Subject: FW: One Stop Store planning application AW/237/19/PL

Further WSCC Highways Response "Comments on Friends of The Ship Inn objection"

Subject: RE: One Stop Store planning application AW/237/19/PL

Title
Site Location Plan with Vehicle Tracking : Articulated Vehicle

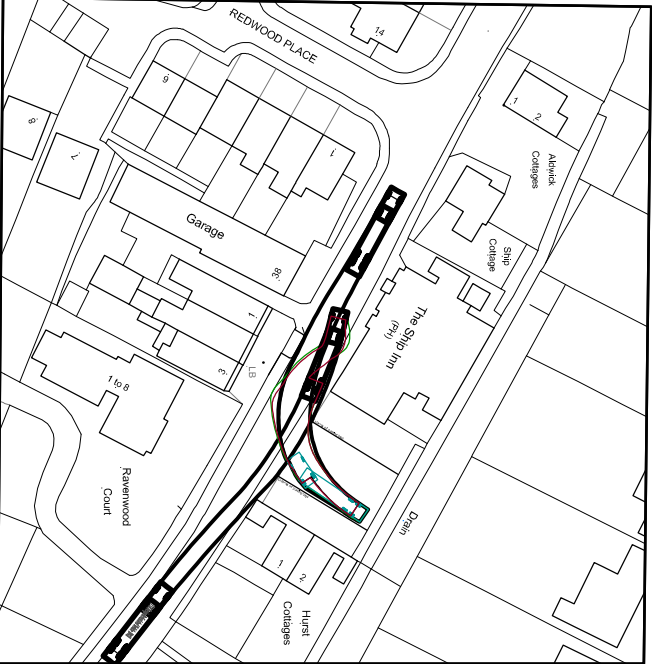
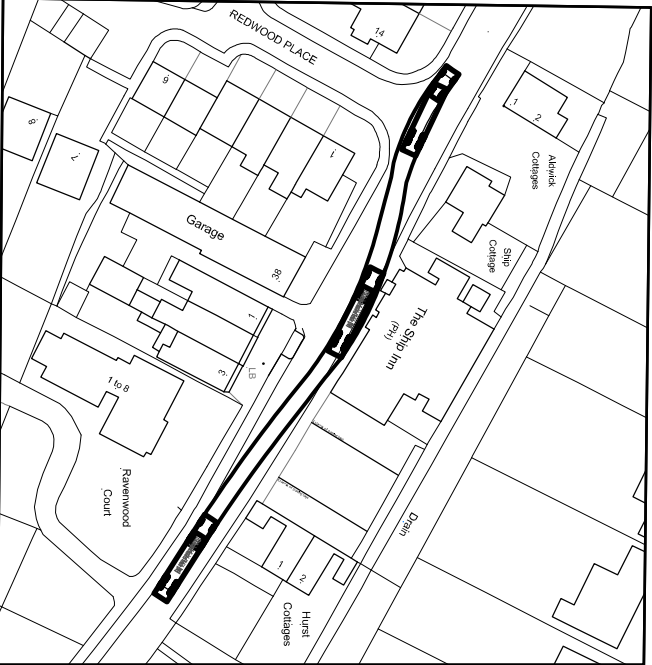
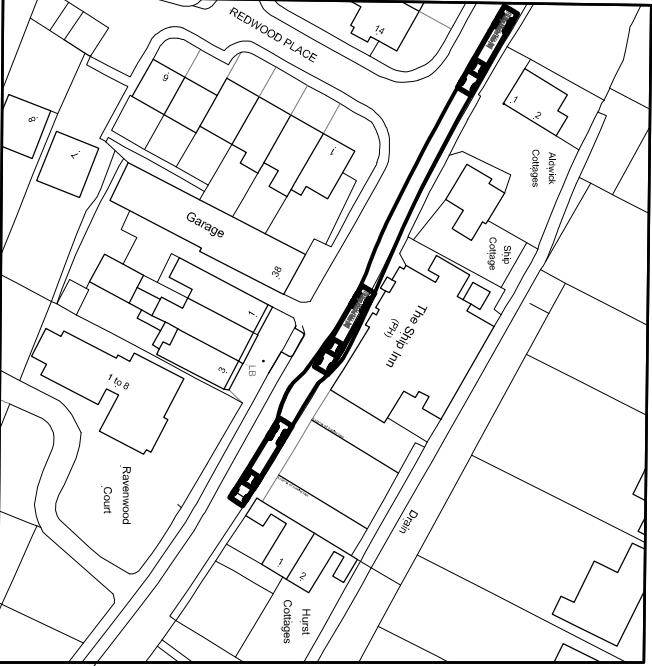
- Are refrigeration vehicles of 2.6m in width likely to use the site and have these been modelled?

- We already gave an answer on the 'two vehicle passing' at the previous DCC. Highways confirmed that it is unlikely to be able to happen when a delivery vehicle is parked outside but this is an 'inconvenience' only; not a significant impact on highway safety. The vast majority of this submission relates to this issue, which we have already commented upon.

We understand the site will be visited by refrigeration vehicles, no details of sizes, only weights are given within the original application. This is detailed in the delivery management scheme attached. None of these refrigeration vehicles have been modelled. The applicant has subsequently advised the refrigerated vehicles are no wider than the rigid vehicle tracking information drawn on the plan, which are detailed at 2.5m. However; based on retained road widths (see plan attached) a 2.6m wide lorry would still leave enough room for a large car 2.01m in width.

As point 1, WSCC find the road width here acceptable to accommodate a 2.6m width refrigeration vehicle waiting in the highway for loading and unloading. As stated previously WSCC raise no issue with traffic giving way to each other, and agree this is an 'inconvenience' rather than a significant highway safety issue. Importantly we asked for the parking lay-by to be included in the swept path diagrams, but these may not always be
